SUBMISSIONS REPORT

URBNSURF Sydney Event Hill Modifications

State Significant Development Modification 07 - (SSD-7942-MOD-07)

10/07/2026

C - SITE SECTION
Scale 1 : 500

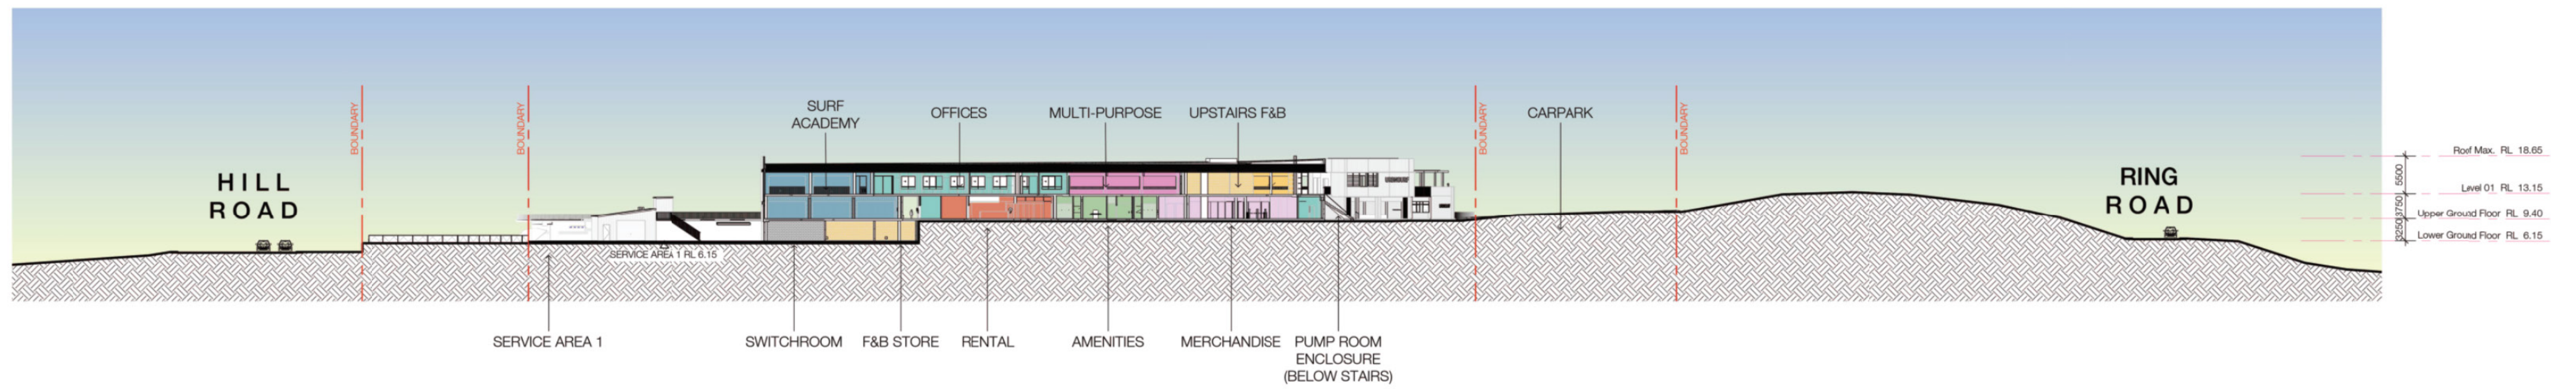
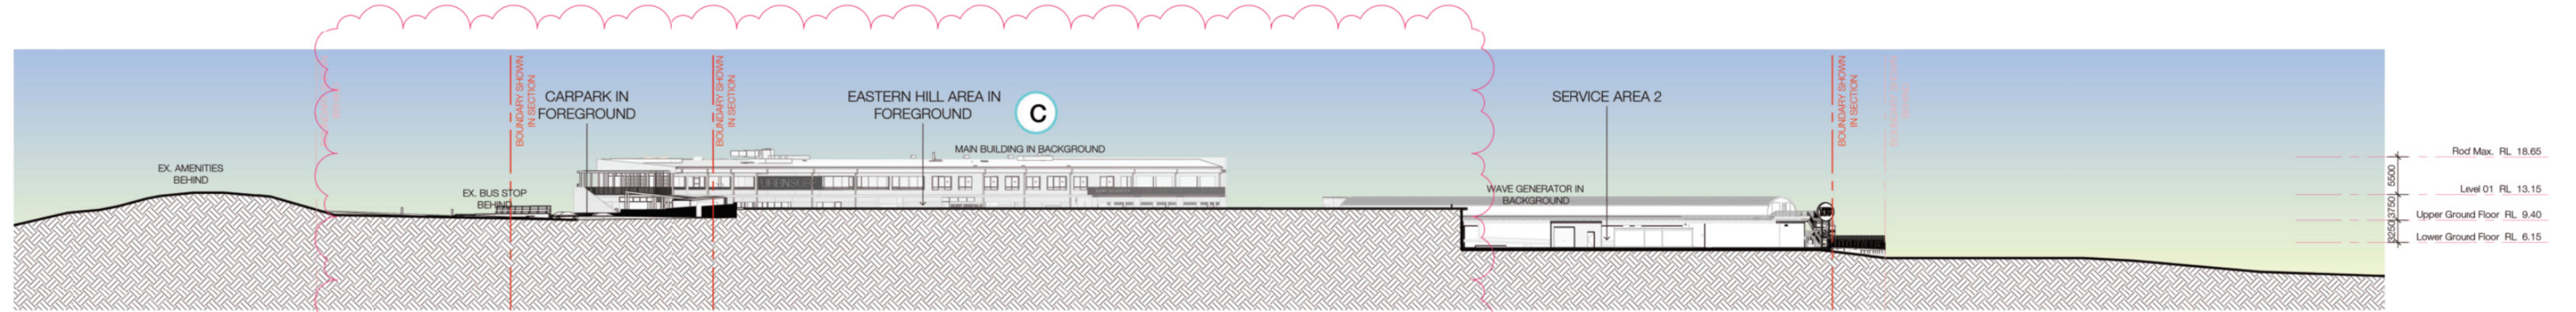
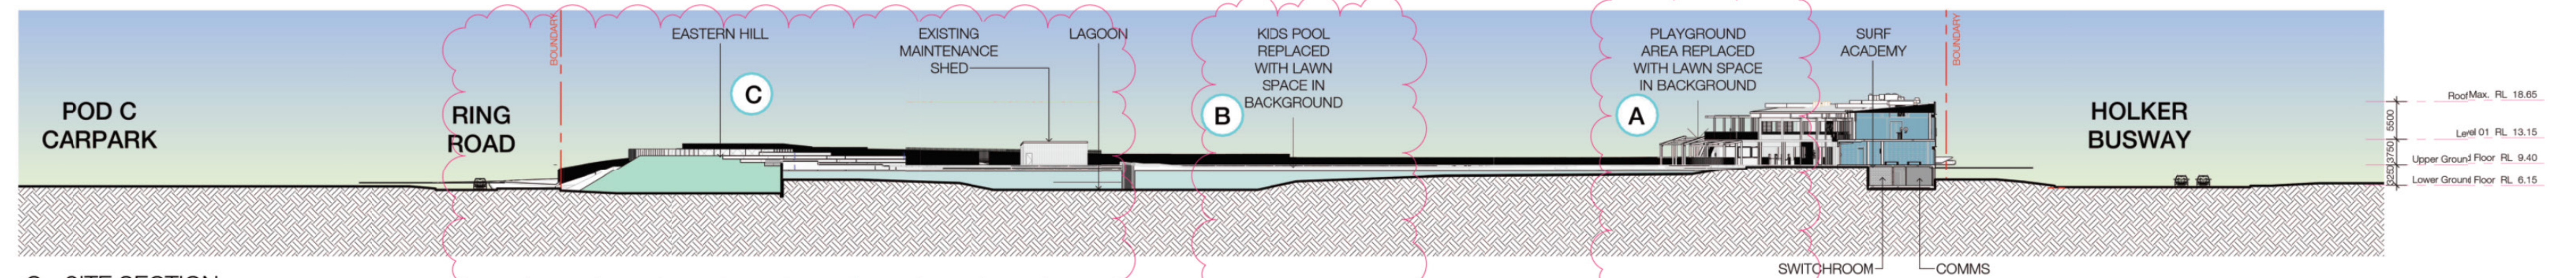
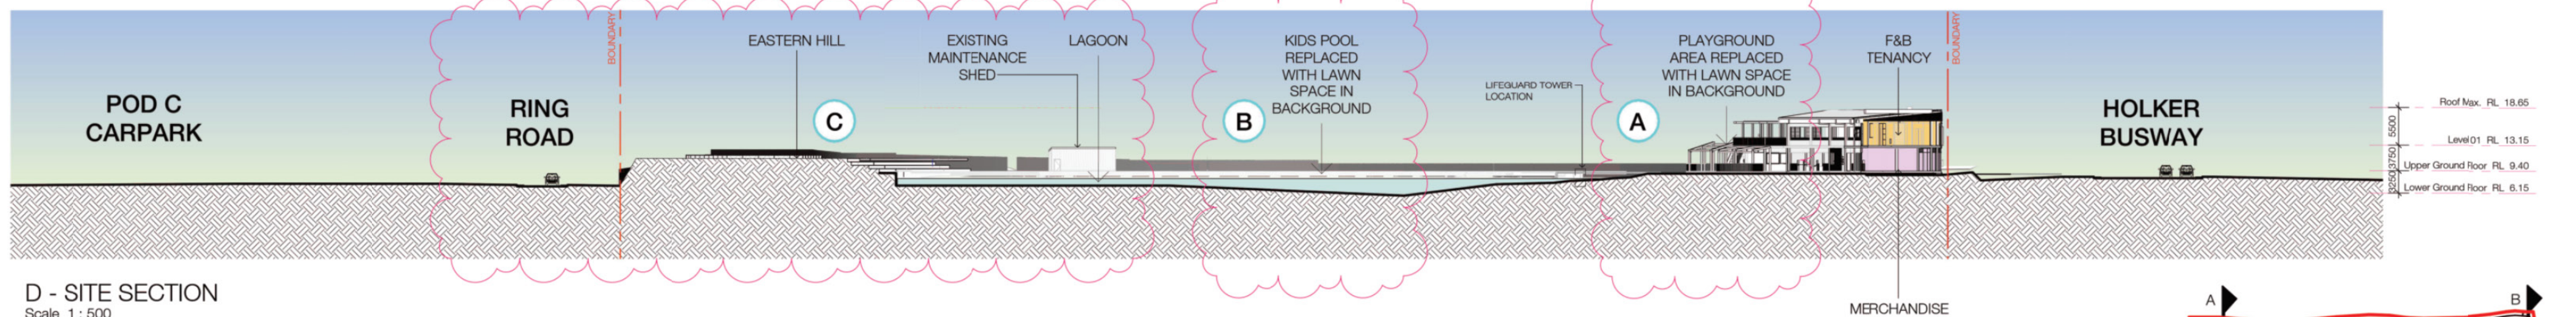
Ref	Issue Raised	Response to Submission	Attachments
1	Clarify discrepancies between the approved sections (from MOD 5) and the proposed sections (C and D) that show a raised fence line and a new building on the southern setback.	The structure shown within the southern setback is the existing maintenance shed located along the southern boundary and does not form part of the proposed works. References identifying this as a new building were carried over from the previously approved Section 4.55 application in error and have now been removed. Similarly, the raised fence line and the annotations stating "NEW RETAINING WALL BEHIND MAINTENANCE SHED" and "NEW RETAINING WALL FENCE OVER" were also inadvertently carried over from the previous Section 4.55 documentation. These are existing site features that were in place prior to the Section 4.55 application and are not proposed as part of the current application. Accordingly, these annotations have been removed from the drawings and should be disregarded.	Attachment C
